March 4, 2016

Subject: Geotechnical Third Party Review
Response to February 4, 2016 Geo Group NW Letter
5637 E. Mercer Way
Mercer Island, Washington
Perrone Consulting Project #15124

**PROPOSED RESIDENCE SECTION**

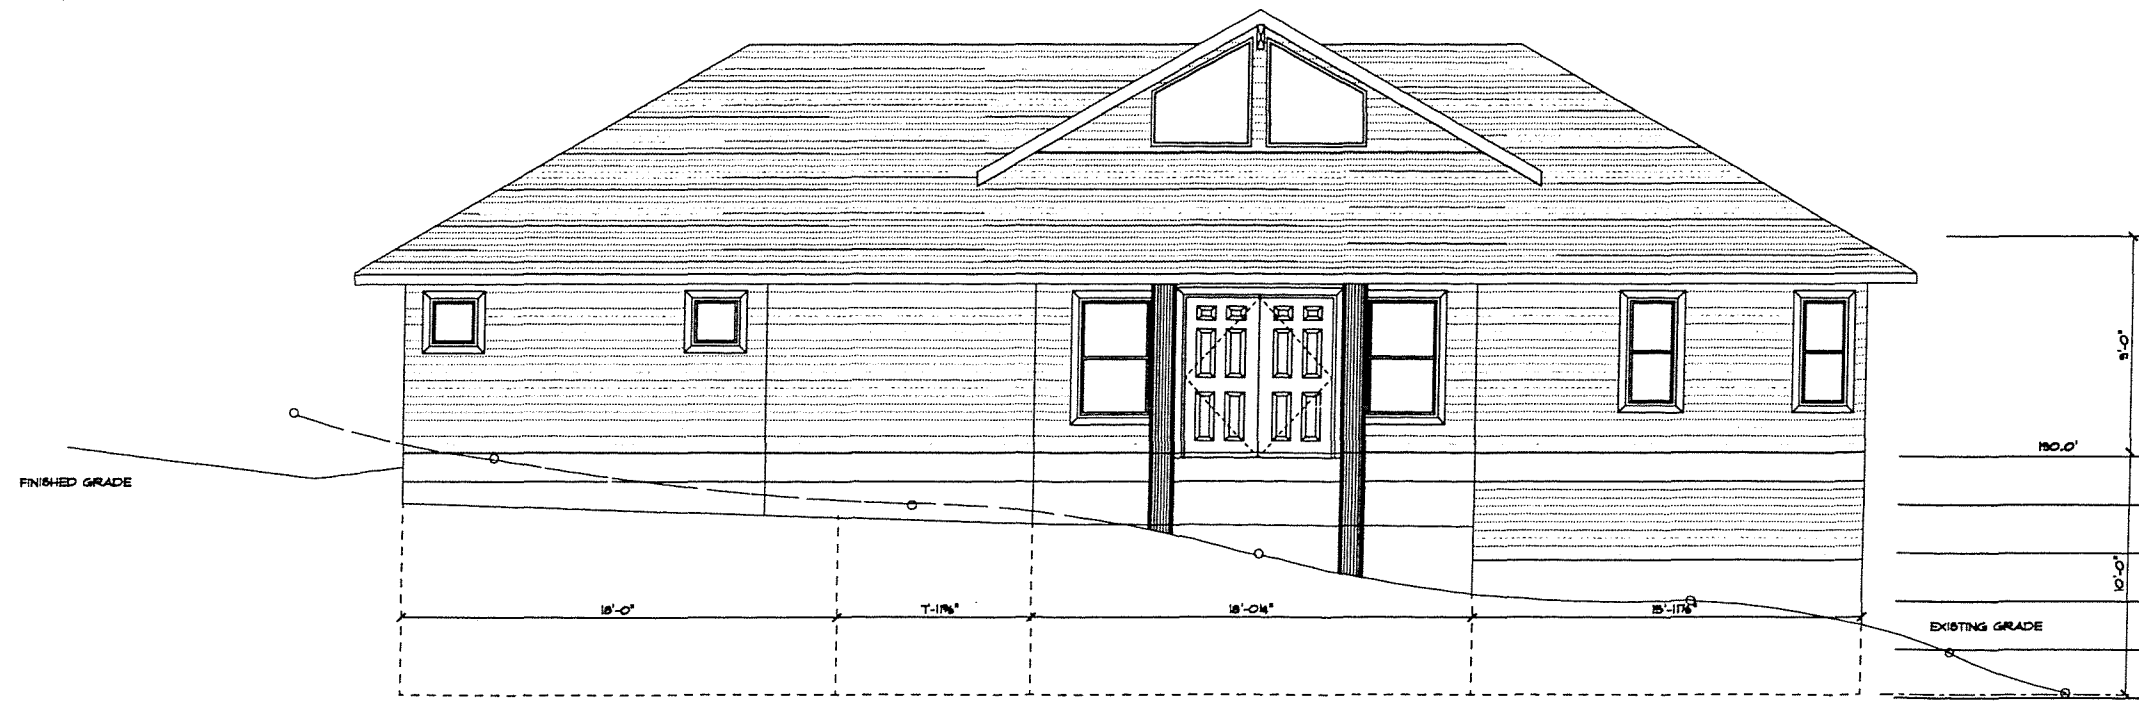
Provide the results of slope stability analyses of the critical slope section for static and seismic conditions, including the effect of liquefaction on soil strength properties.

Revised slope stability computations were provided for long term static and seismic conditions and for temporary excavation slopes. We understand that the temporary slopes will be dewatered prior to excavating to a 1H:1V configuration. The computed factor of safety for temporary slopes was 1.15 which is less than generally accepted minimum value of 1.3. Similarly, the long term static factor of safety is 1.22 which is less than the minimum acceptable value of 1.5. Accordingly, the engineer should provide recommendations to increase the stability of the temporary excavation to acceptable levels. In addition, recommendations should be provided to either increase the long term stability of the slope or provide a catchment wall with sufficient capacity to restrain potential slope failures with factors of safety less than 1.5 (see Request 4).

The results of the seismic stability analyses are uncertain since Geo Group NW indicates that the input horizontal seismic coefficient, $k_h = 0.09g$ in Attachment 1 whereas the report text indicates they used $k_h = 0.15$ which is the same value used in the previously reported analyses (Geo Group NW, 2015). The computed factor of safety for $k_h = 0.09g$ is 1.01.

As stated in our previous review, the horizontal seismic coefficient, $k_h = 0.15g$ is not in accordance with the standard of practice and IBC 2012 which is incorporated as part of the City of Mercer Island's Building Code. Geo Group NW references published research (Melo & Sharma, 2004) as a basis for using $k_h = 0.15g$. However, the researchers concluded:

Based on this research and a peak ground acceleration of 0.6g, the recommended design $k_h = 0.24g$ to 0.27g. Revised seismic slope stability computations with the larger ground accelerations

should be provided and the output results should show the limits of the slide mass with factors of safety less than or equal to 1.0. Recommendation should be provided to increase the seismic stability of the slope or provide a catchment wall that can restrain potential seismic slope failures with factors of safety of 1.0 (see Request 4).

Based on the results of the stability analyses, provide design parameters for the foundation/catchment wall including impact forces and an estimate of the wall height based on the volume of future landslide debris.

Recommendations have been provided for foundation/catchment wall lateral earth pressures. Geo Group NW has recommended an 8 ft high catchment wall based on the results of their static and seismic slope stability analyses. The seismic slope stability analyses should be revised based on higher k_h values consistent with IBC 2012 (see Request 3). These seismic and static slope stability results, and the distance of the house foundation wall from the slope failure should be used as a basis for determining the catchment wall height needed to contain the unstable volume of landslide material defined by the slope stability analyses.
